Please ask for: Nicola Moore
Email: nicola.moore@arun.gov.uk
Telephone: Ext 37944
Our Ref: EP/156/21/CLP
Your Ref:
Date: 25th November 2021

Lawful Development Certificate for a Proposed Use or Development

Development: Lawful development certificate for a proposed single storey rear extension
Location: 24 Meadow Park East Preston BN16 1EG

PROJECT		
Proposed Rear Extension		
ADDRESS		
24 Meadow Park East Preston West Sussex		
TITLE		
Site & Location Plan		
CLIENT		
Mr & Mrs Ward		
DRAWN	STATUS	DATE
JLB	Design	26/10/21
SCALE (@ A3)		PROJECT NUMBER
As indicated		KD.1241
DRAWING NUMBER		REV
A.001		A

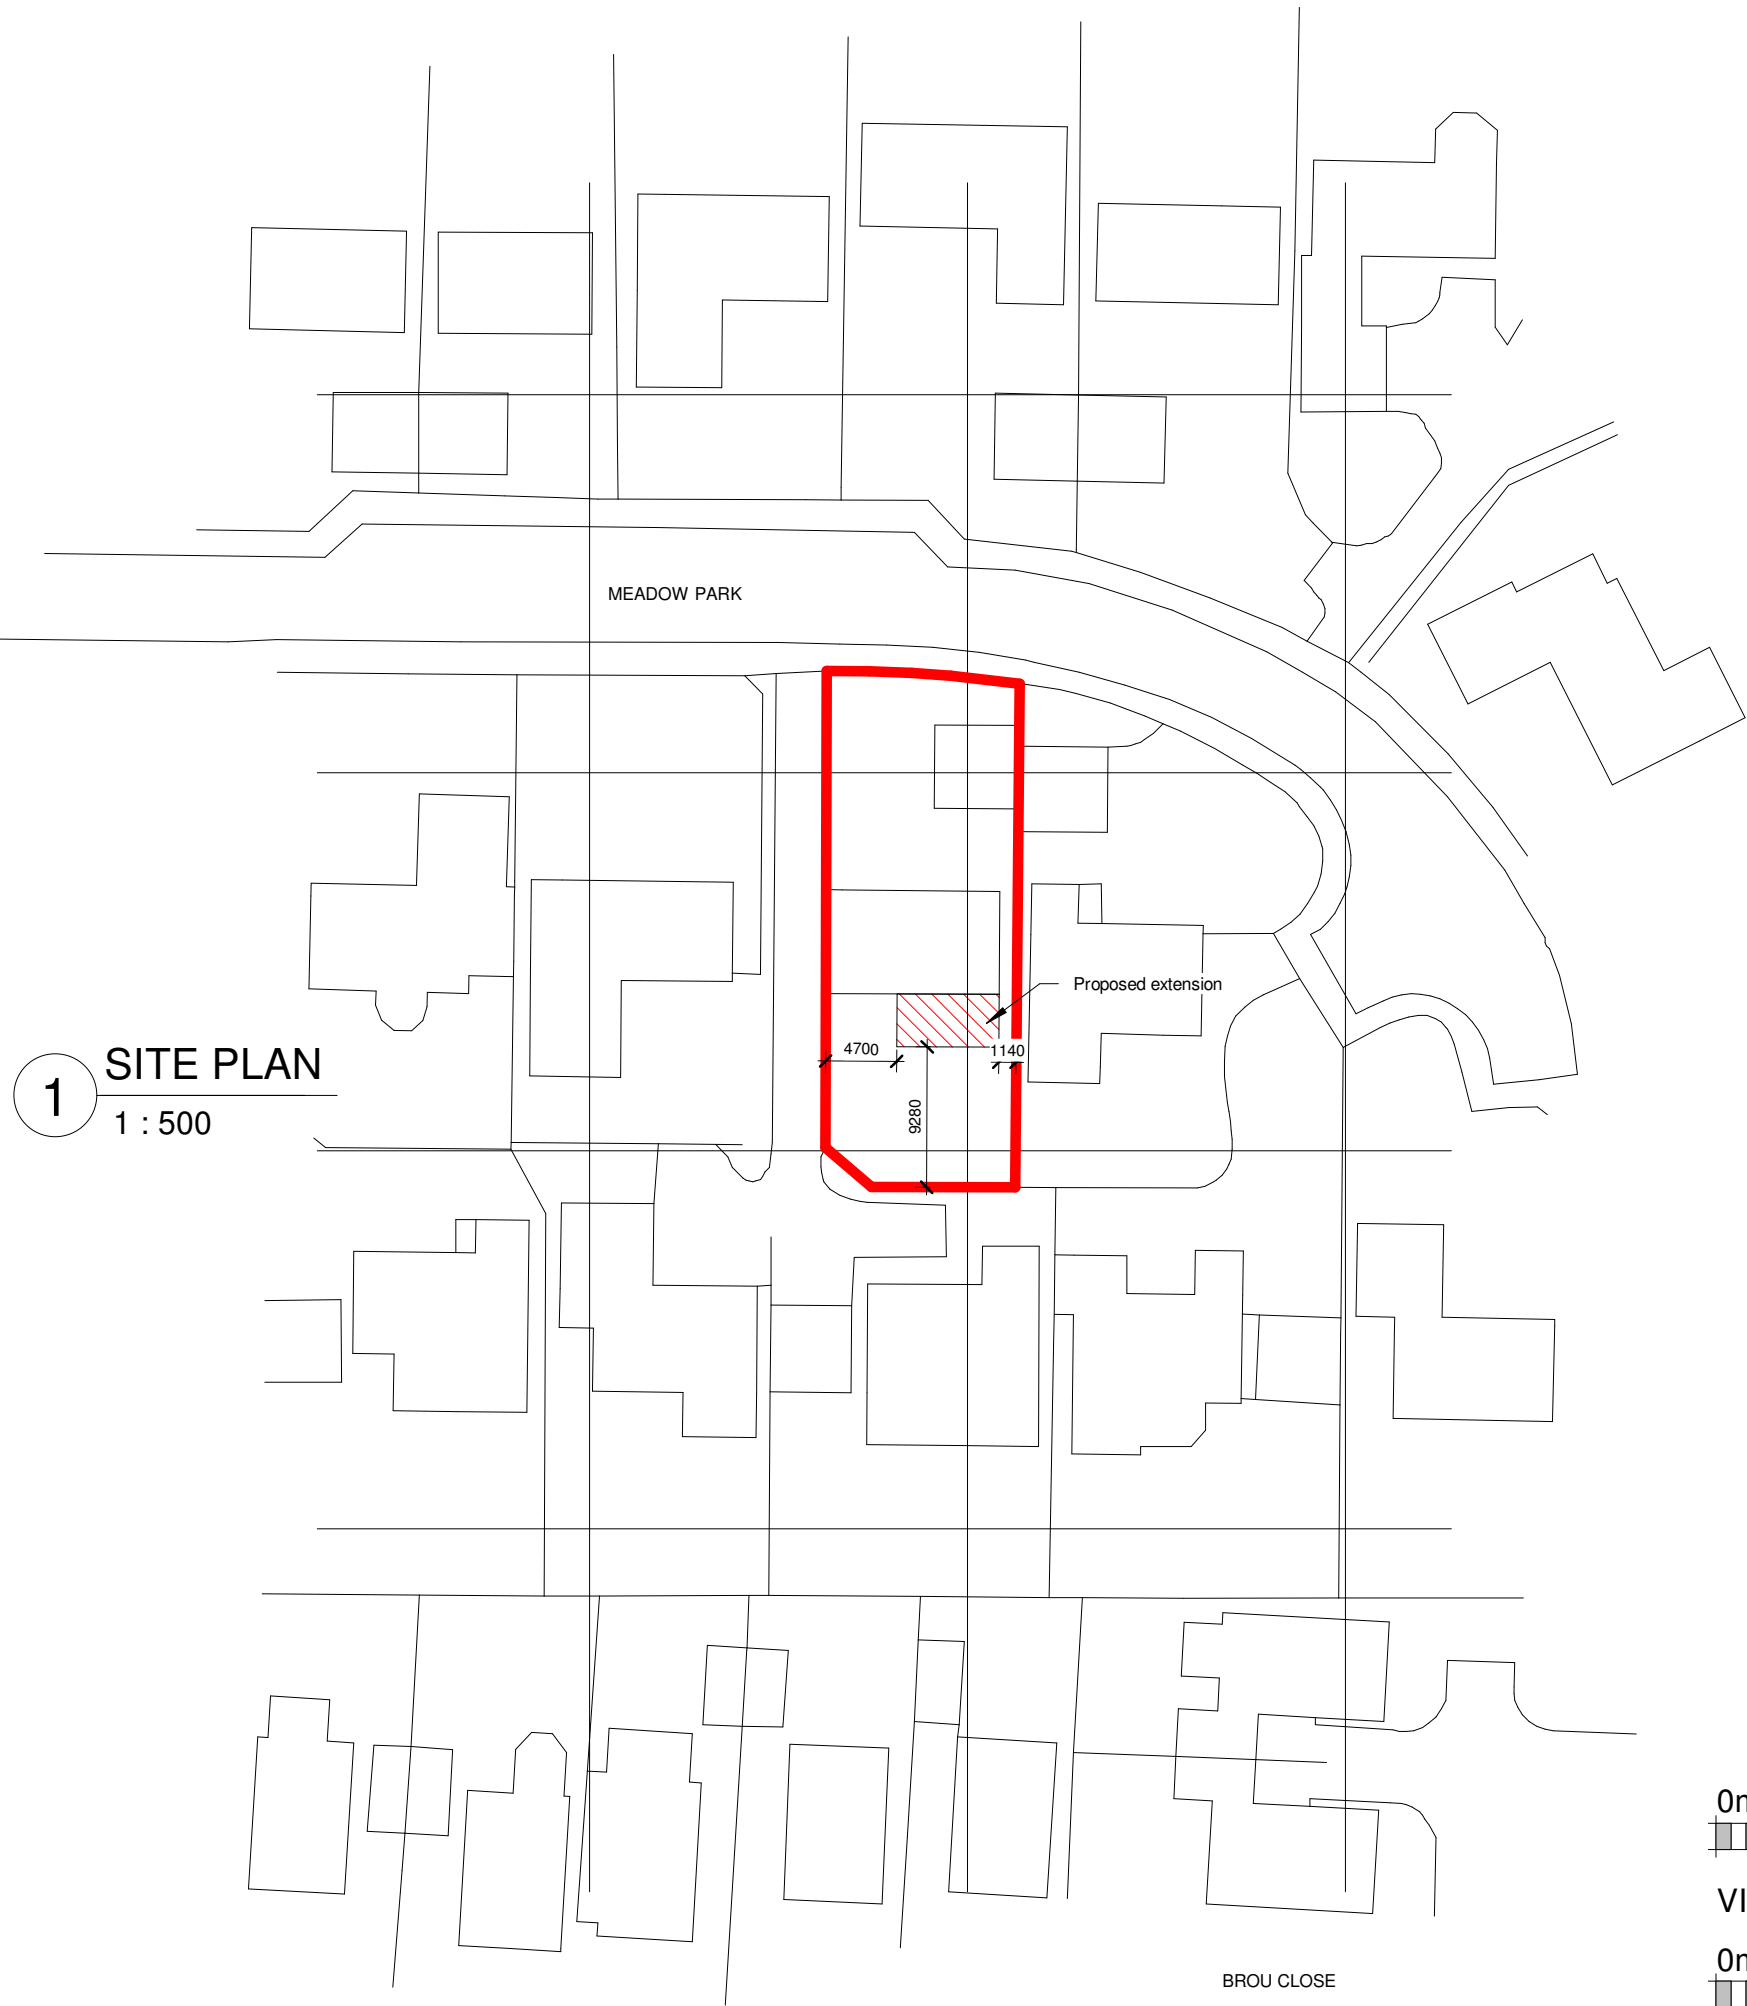
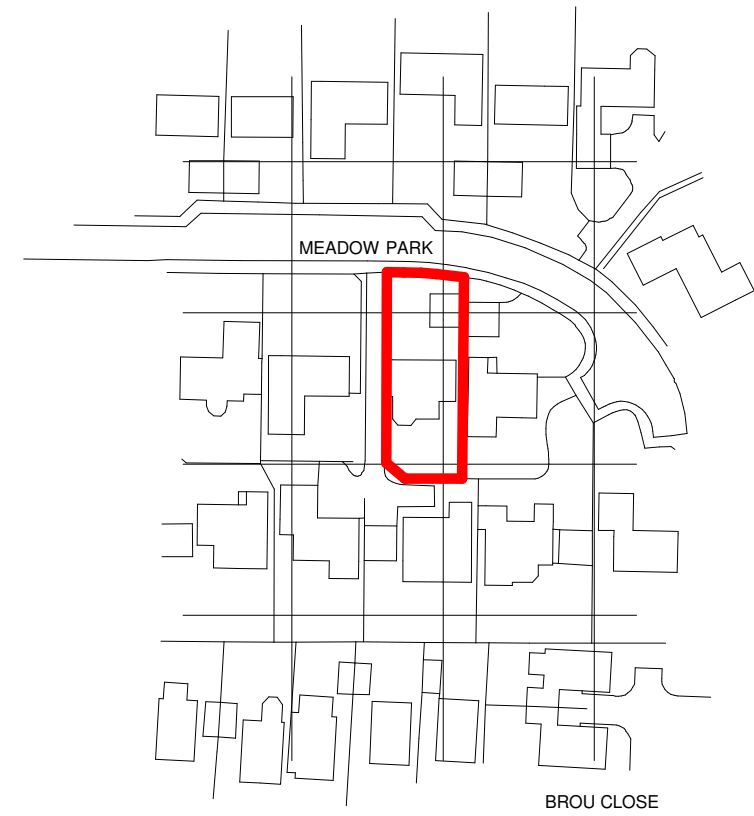
Block Plan

Please amend the Block plan to include distances to boundaries from the proposed extension and re submit. Further details of what must be included on the plan can be found in the Validation Requirements List.
